Response to Planning Application

From: Arun District Council Greenspace

Application ref: P/18/20/PL

Description: Change of use from highway land to residential use for the development of 4 No. 3 bed terraced houses with associated parking & access. This application affects the setting of a listed building.

Tree Retention Protection Plan

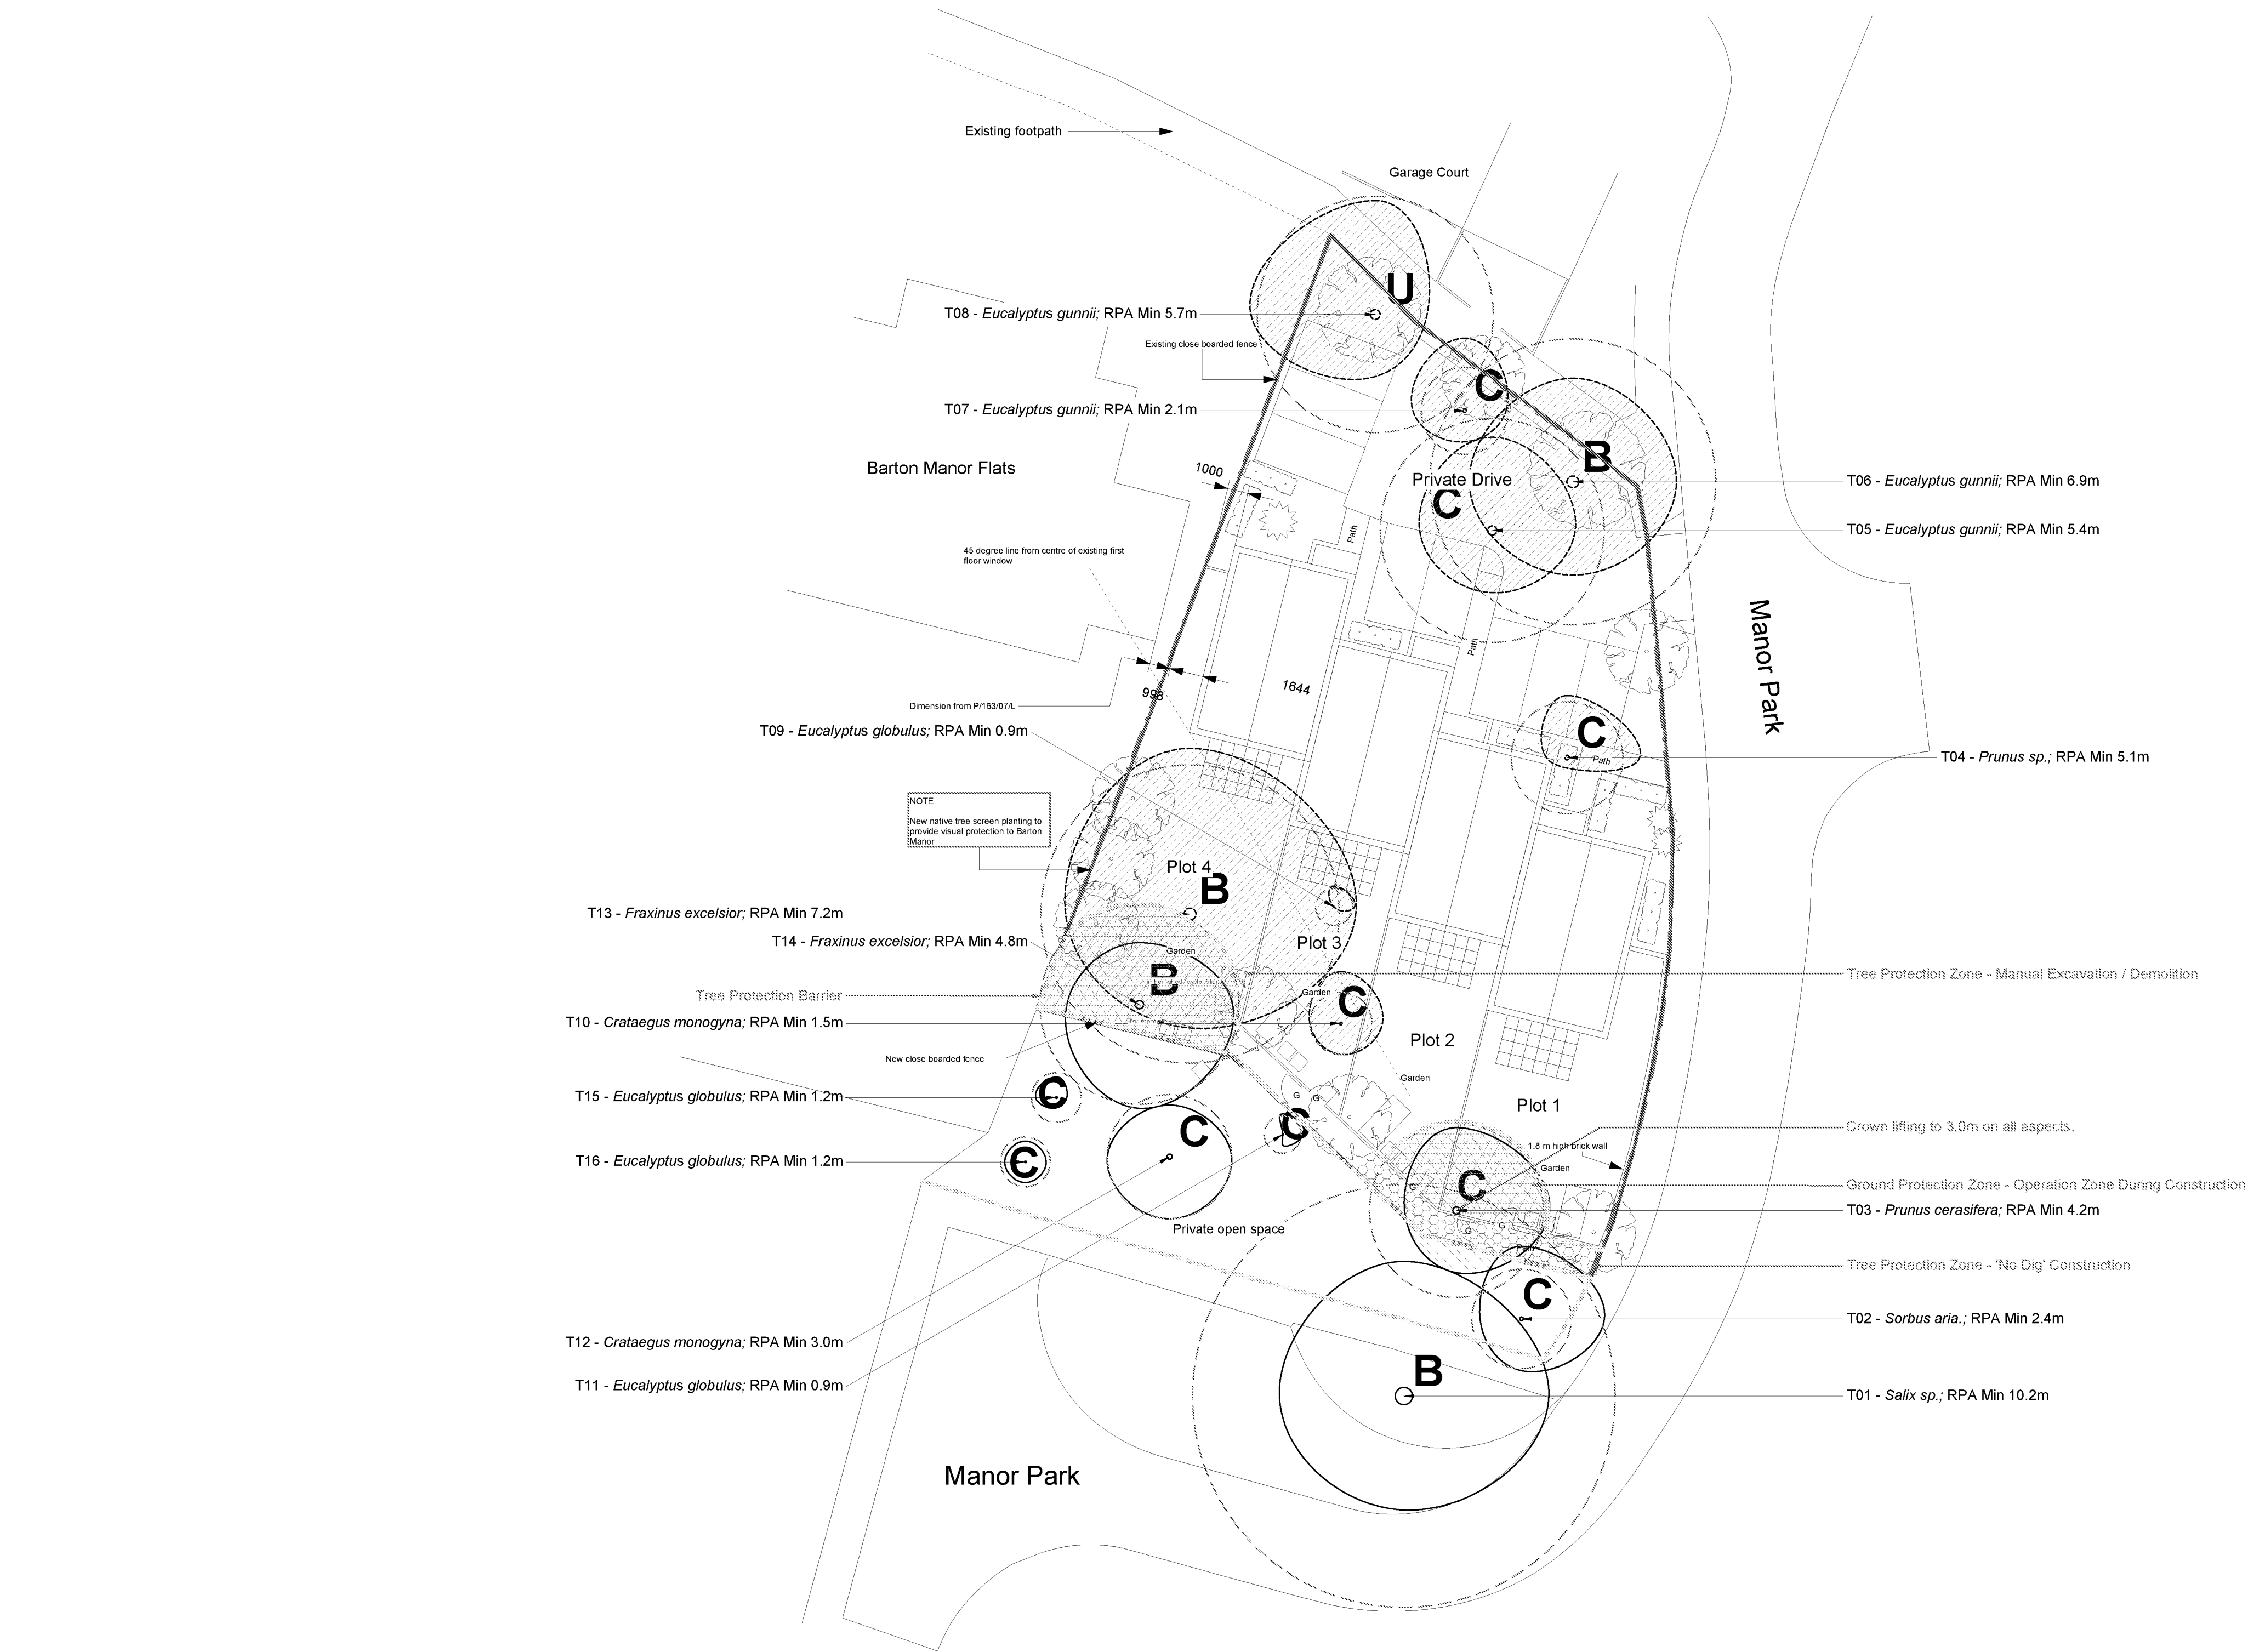
The NPPF para 124/127 relate to good design principles which equally apply to small infill development. The indicative landscape proposals in Site plan drawing 529/02 has made brief reference to indicative planting and onsite tree retention. These details would require expanding in the form of a detailed planting plan and specification detailing species choice, actual plant quantities, planting densities and size at time of planting. Detail should also be provided regarding existing trees which will need to be protected from root incursion and details re the protection of these to be provided and approved.

I would recommend no landscape objection to the proposals subject to submission of landscape details to provide ornamental and native improvements, screening and potential biodiversity gain. To confirm tree protection methods in relation within and beyond the site boundary that may be affected by the development proposals.
